February 28<sup>th</sup>, 2017

This letter is in response to the request for further information by the City of Mercer Island Development Services Group in order to complete processing of our application for fence height deviation (DEV17-001). I have addressed each item brought up by the City in numerical order.

FENCING PLAN

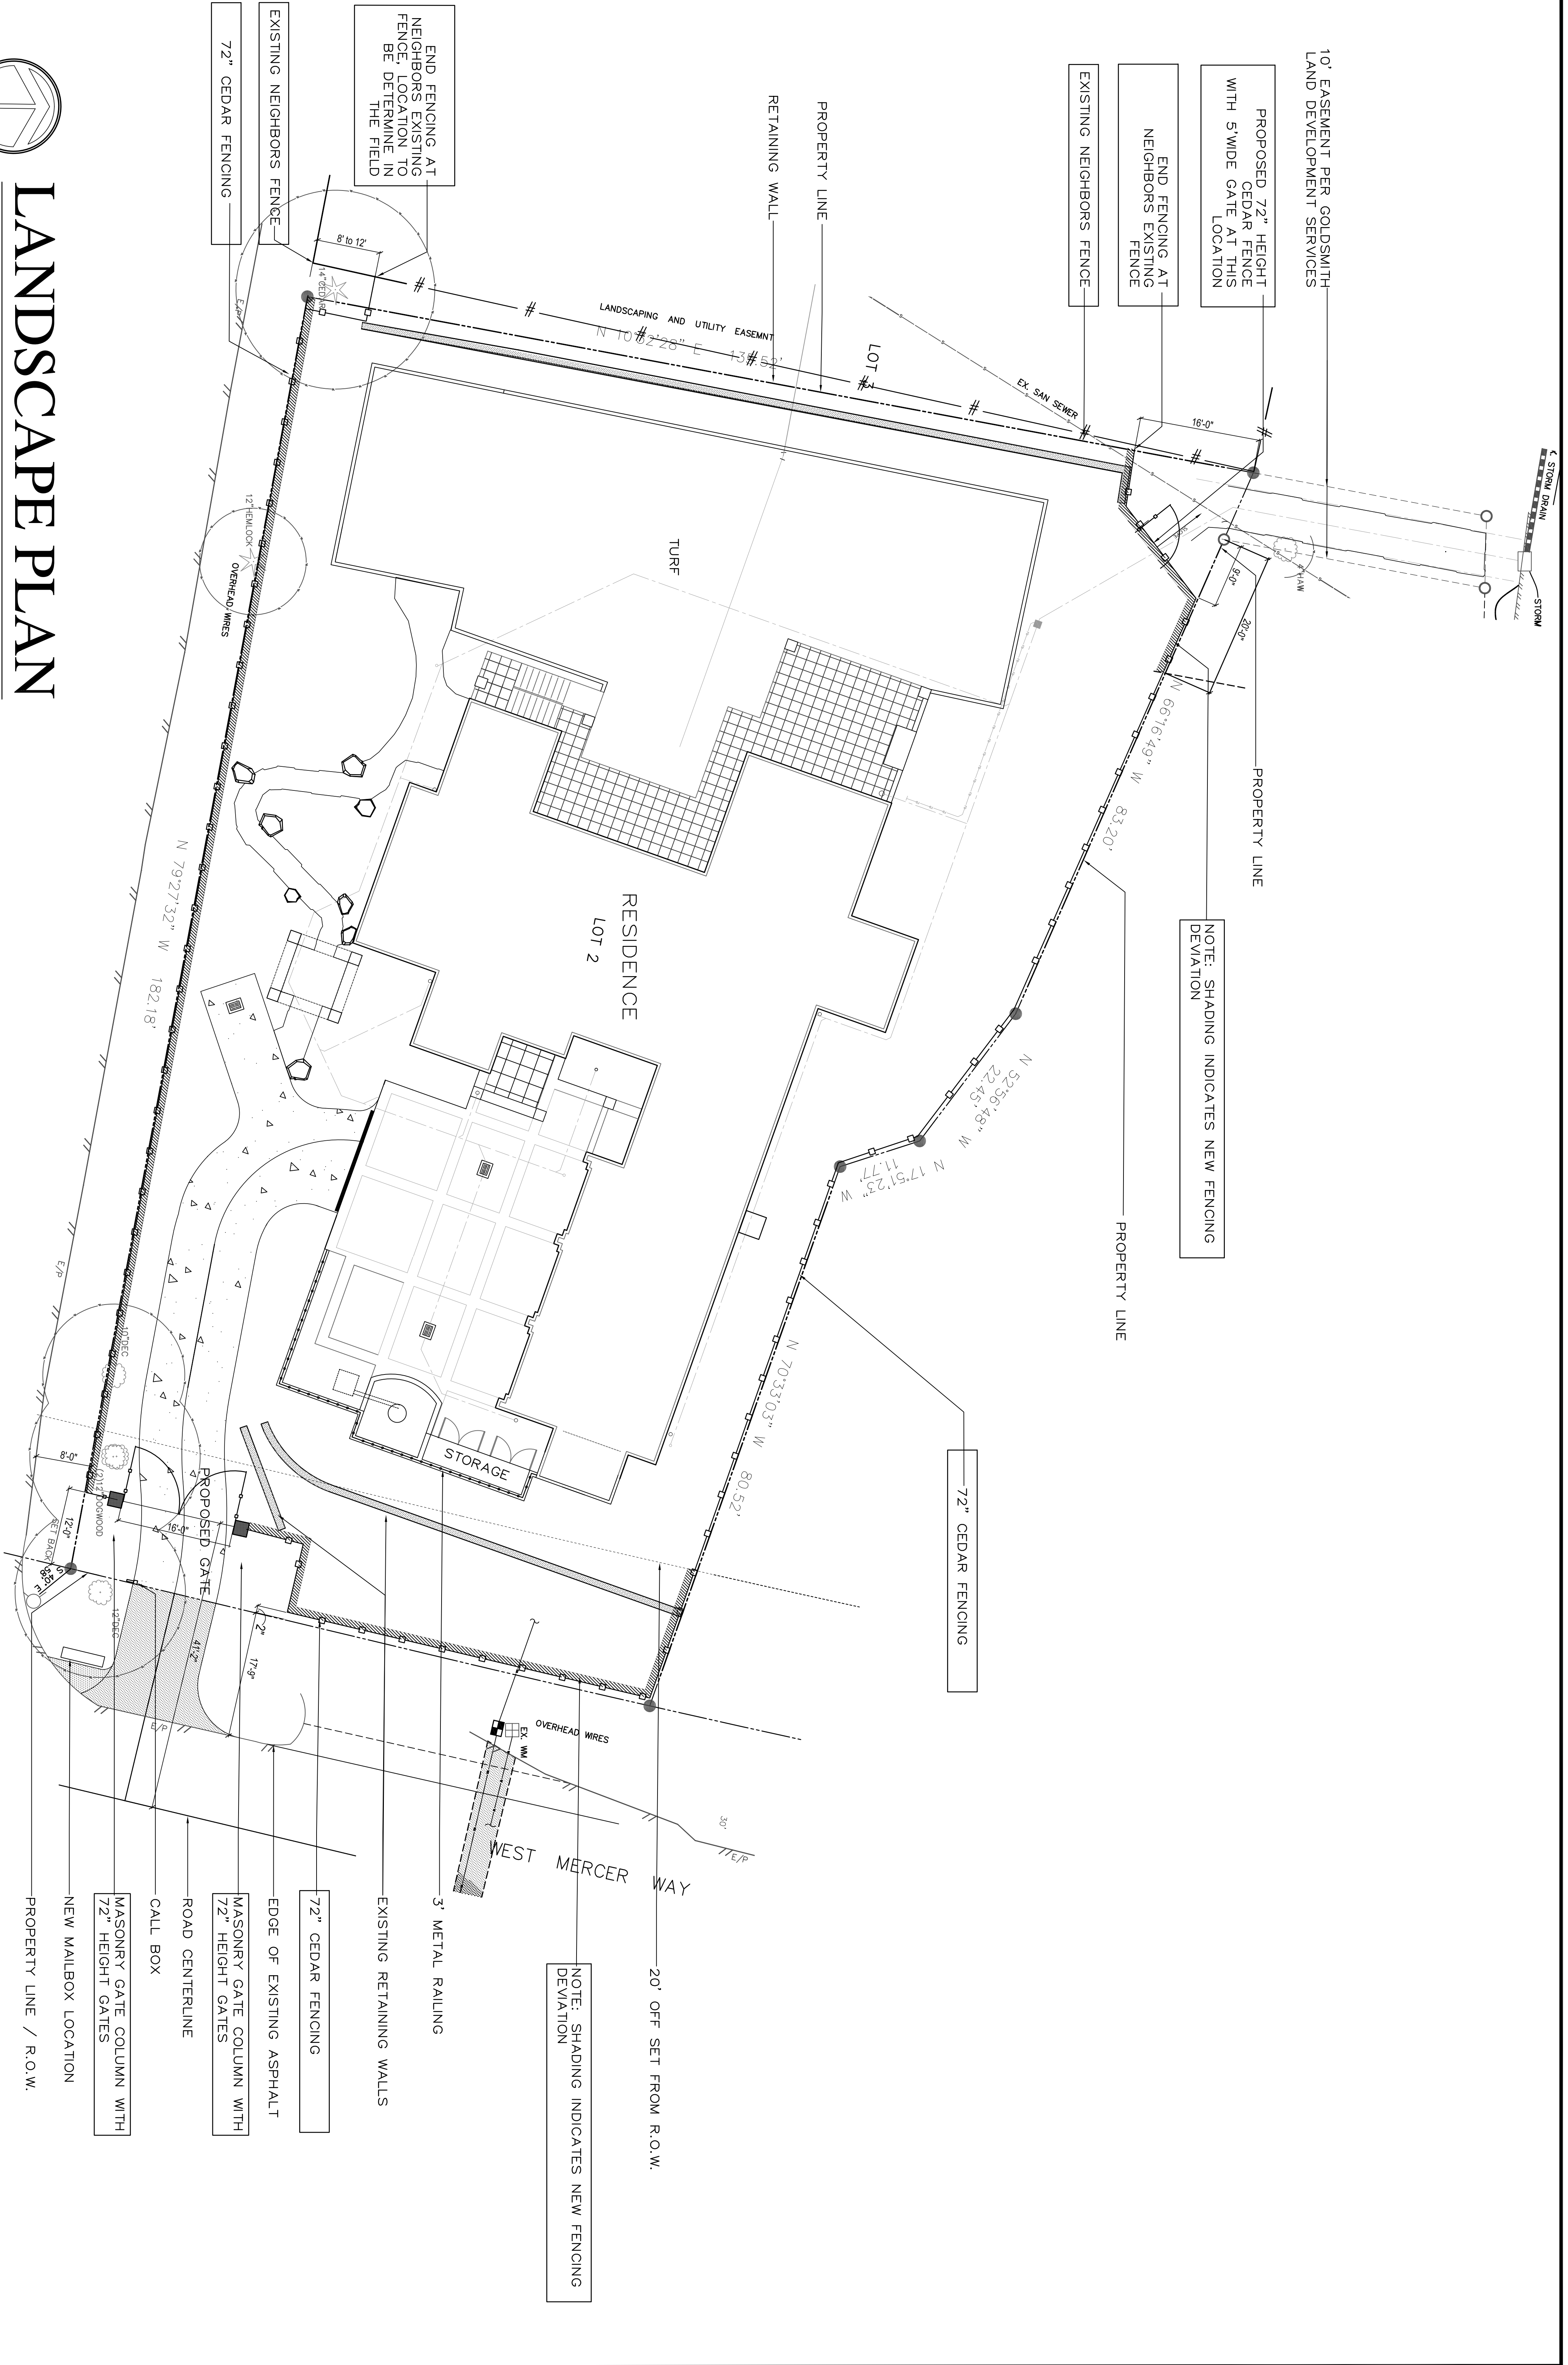
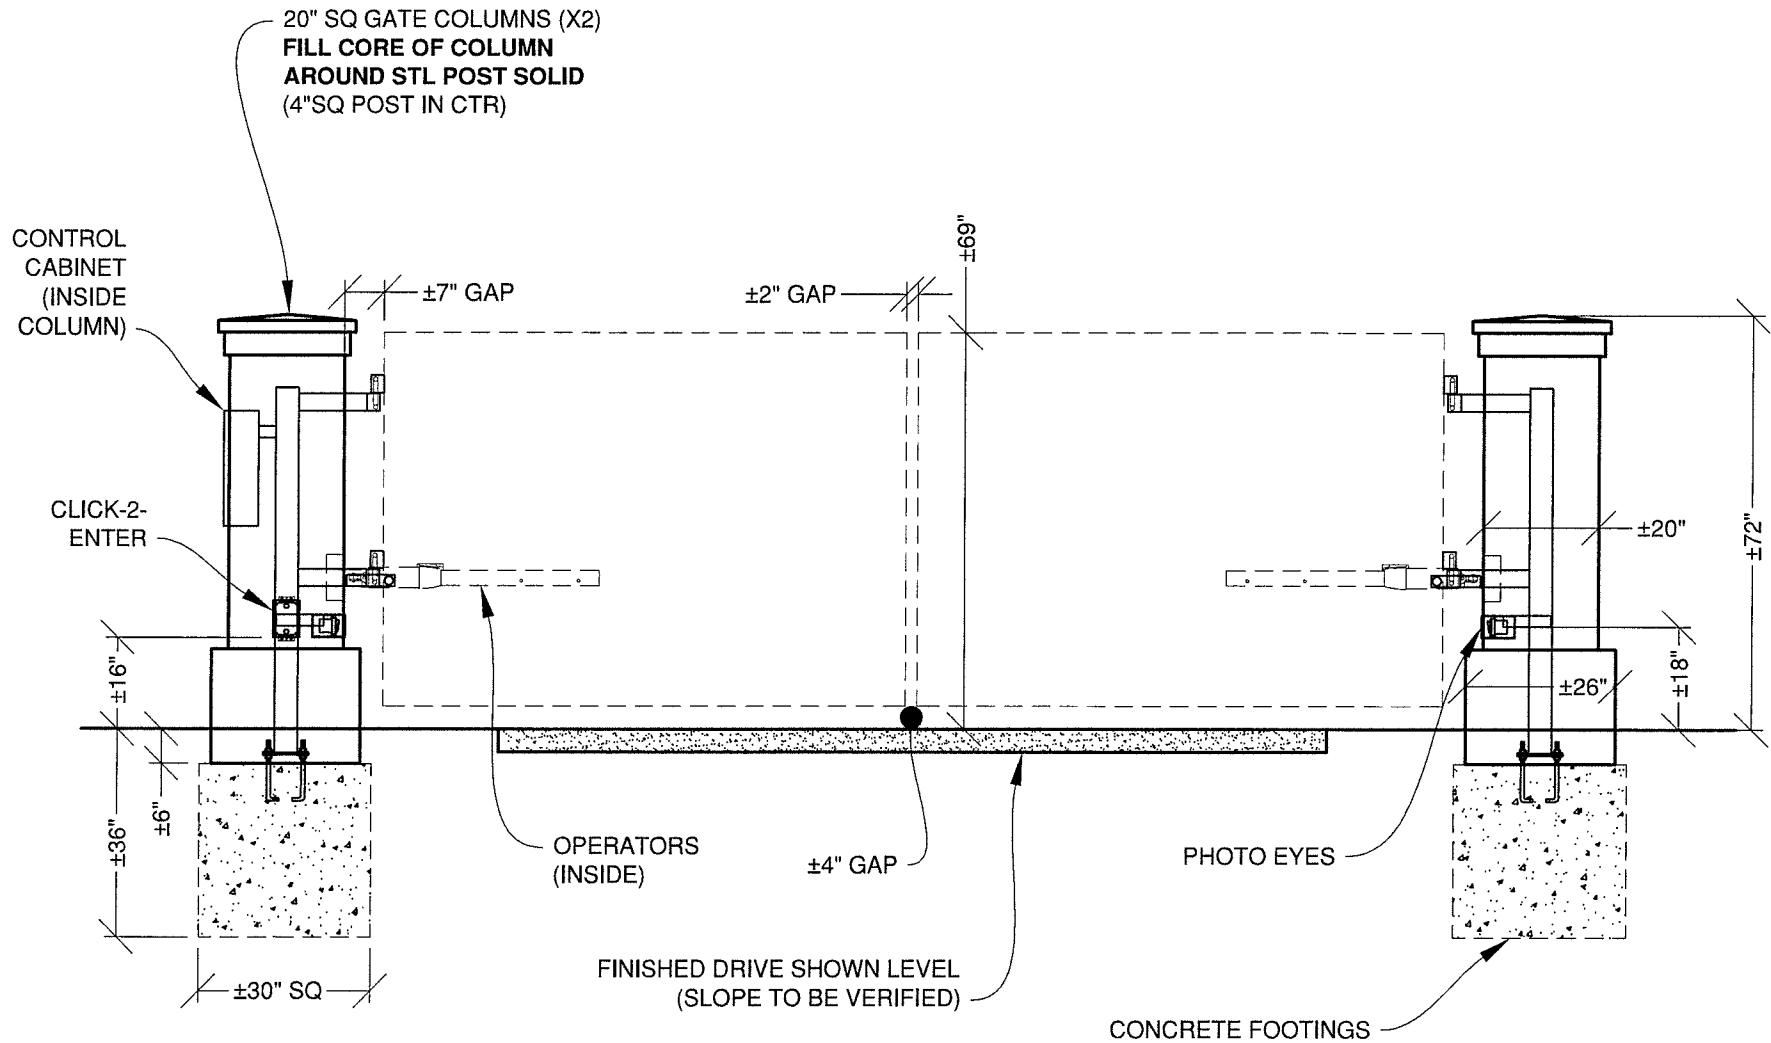
2. The fence height deviation request is for the following locations: A. Along the south side of the property due to the shared access drive there. B. Along the east side of the property bordering West Mercer Way and along the north side of the property for that portion of the fence less than 20 feet from the improved street. C. In the northwest corner of the property for that portion of the fence less than 20 feet from the access easement across the bottom of our northern neighbor's lot. In all these locations, we are requesting that our fence be 72" in height to match the remainder of the fence around the property. Please see the attached drawing showing the location of the fence as well as the portion of that fence where the deviation in height is requested.

4. Please see the attached additional site plan without contour lines and vegetation, which shows the distance from the proposed gate and fence to the edge of West Mercer Way, as well as the distance from the proposed gate and fence to the driveway abutting the South end of the property.
5. Please see the attached rendering of the 5 foot wide gate at the Northwest corner of the property. Essentially this will be identical to the adjacent fence, but function as a gate.
6. The timeline for installation and completion of the proposed vegetation plan is beginning in the next few weeks with completion expected approximately 3 to 4 weeks later. Our landscape contractor is currently looking for time to get our project on his schedule.

**GATE OUTLINE**

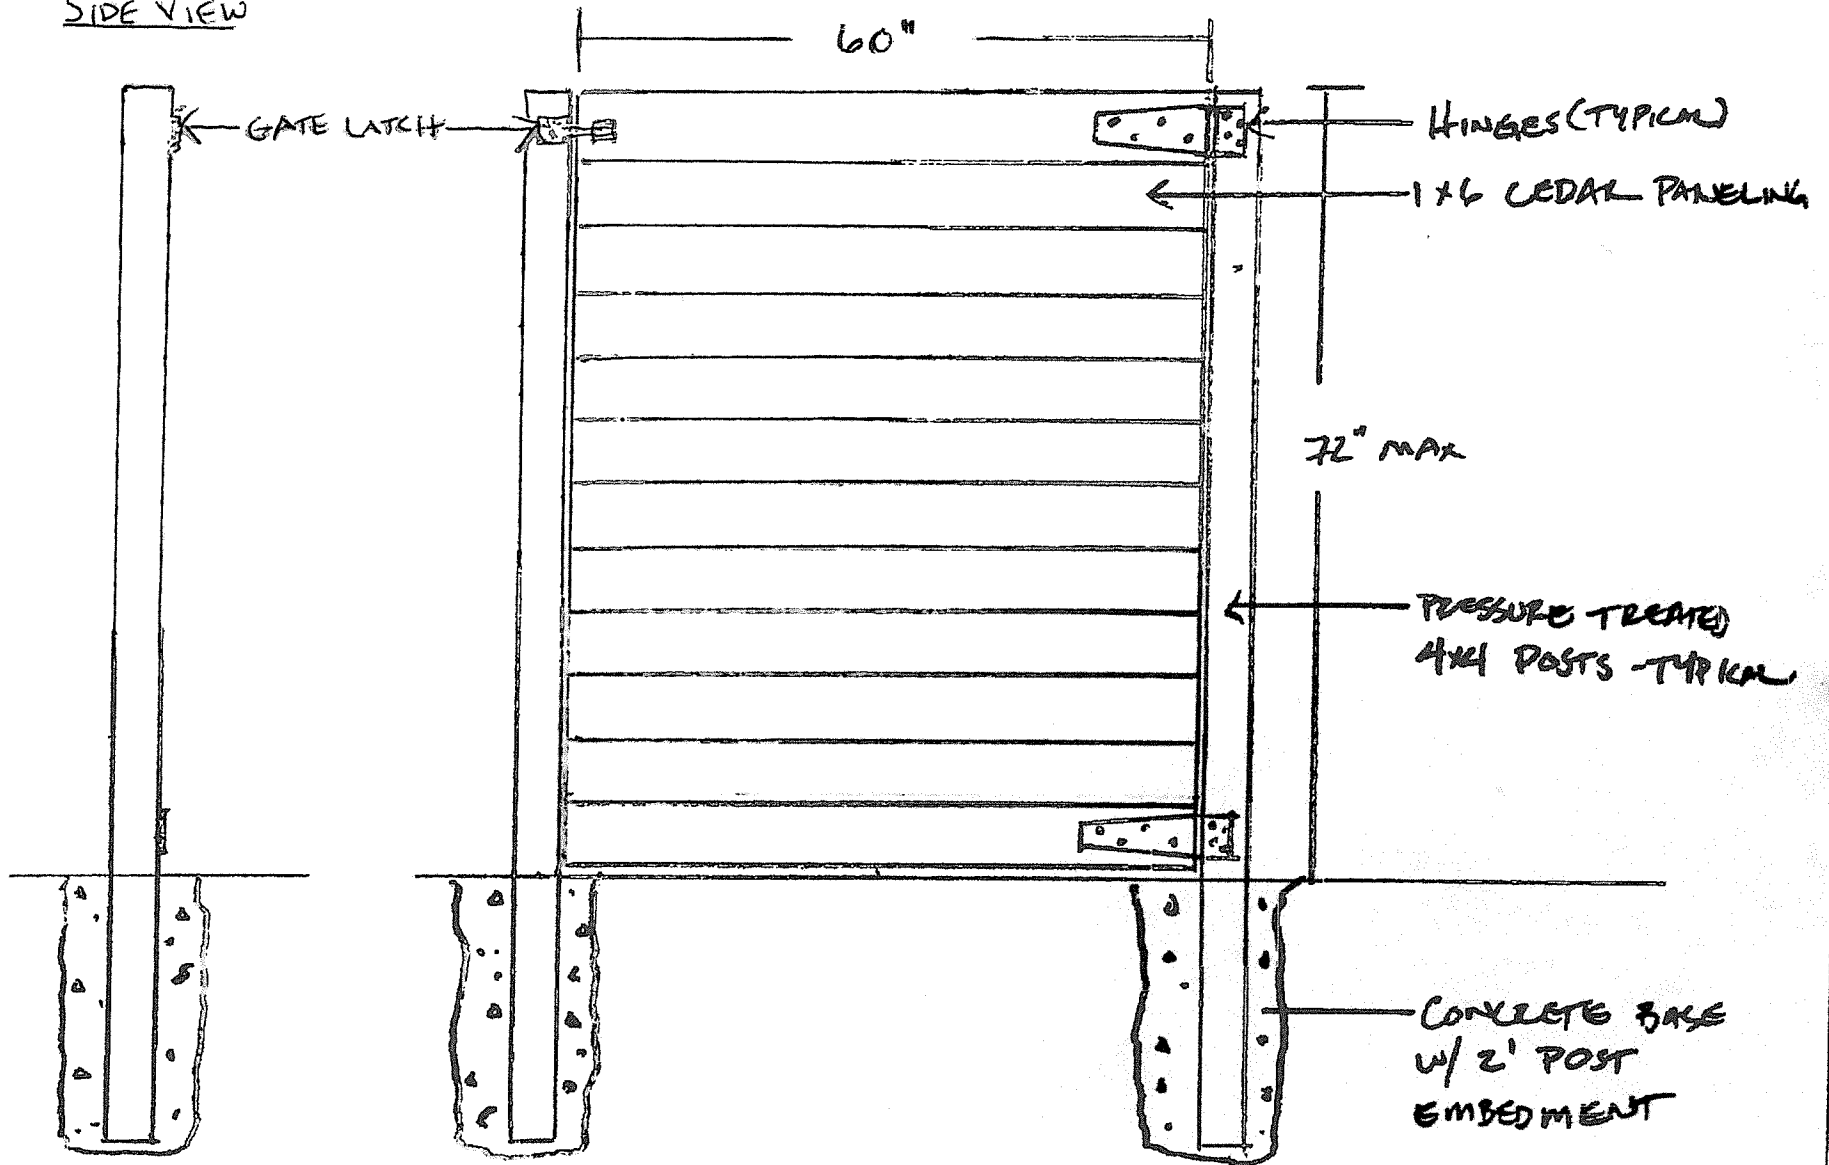
1. We will revise the plans to reflect a maximum fence height of 72". We will reduce the side posts to 72" and the gate itself will reduce in height to 69". A revised set of gate plans is attached for review.
